ASSOCIATED BRITISH PORTS COMMENTARY

Able Marine Energy Park

Commentary to accompany ABP's changes to Revision 5 of the Draft Able Marine Energy Park Development Consent Order dated 26 October 2012.

Drawing file: TR030001 / TR030001-000479-Works Plan Sht No. 1 of 14.pdf

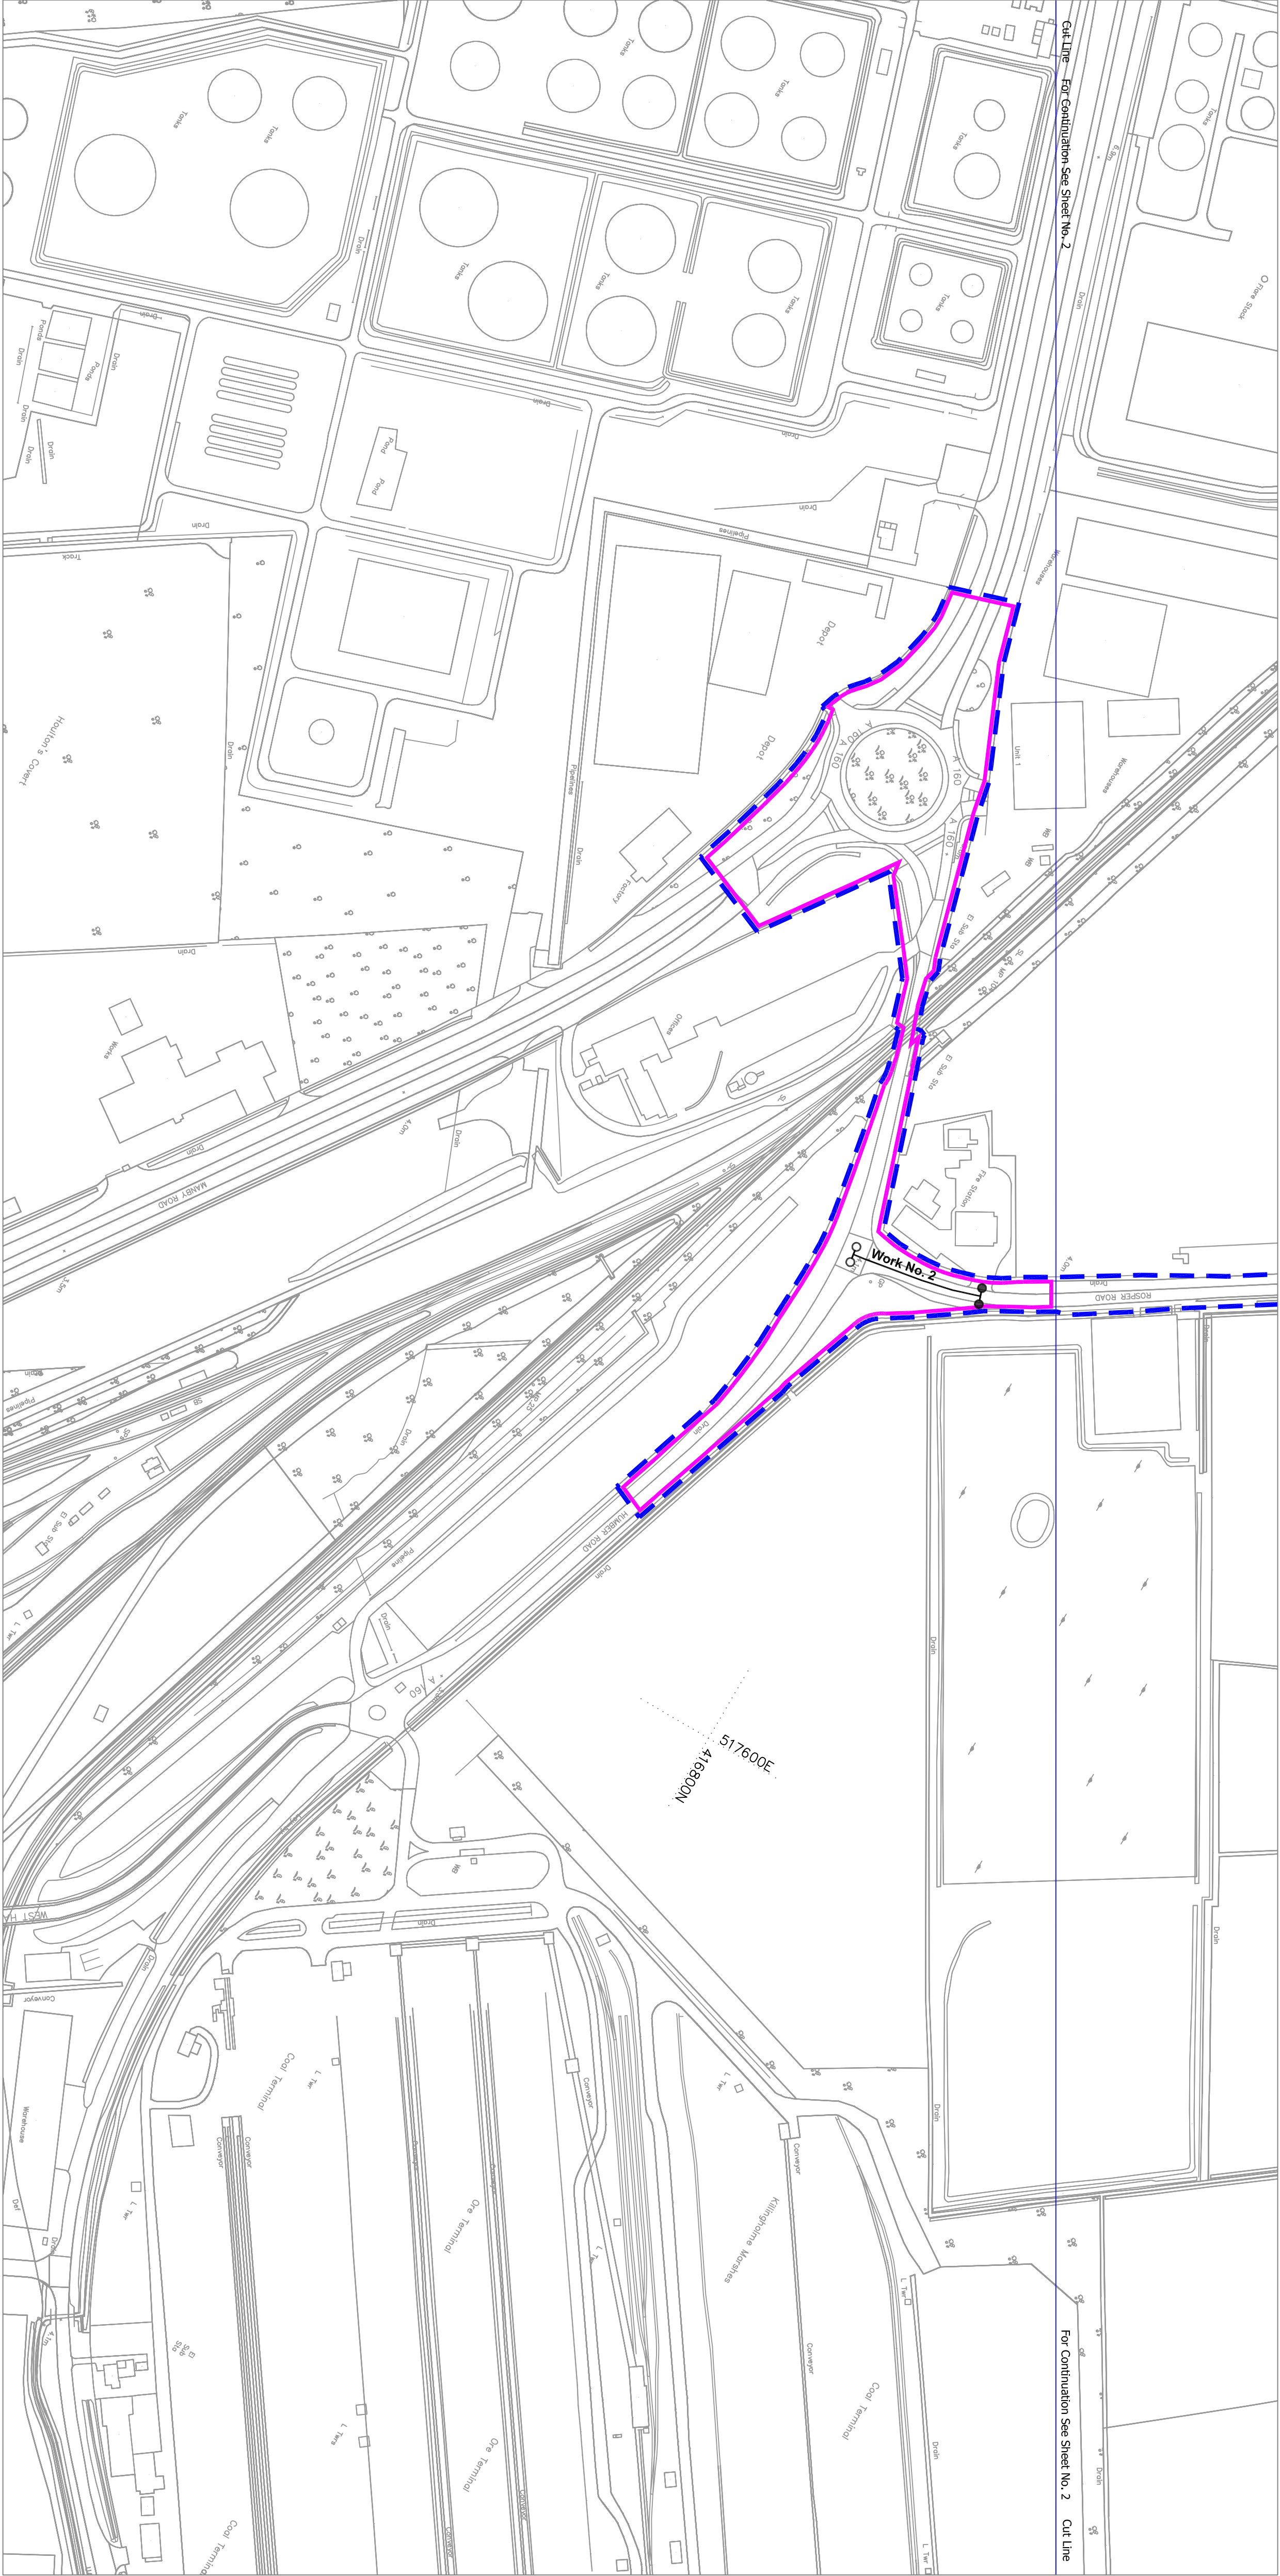
(i) Although limits of deviation, a centre line, a commencement point and a termination point for this work are shown on the revised works plans that accompany revision 5 of the draft DCO (Sheet No.1) there is, as far as ABP can currently determine, no detail provided in the draft DCO or accompanying plans and drawings as to what these works comprise.

(ii) If this work is only described as improvement works to the junction of Humber Road and Rosper Road, it is unclear why the limits of deviation shown extend out to include the junction of Humber Road (A160) and Manby Road (A1173).
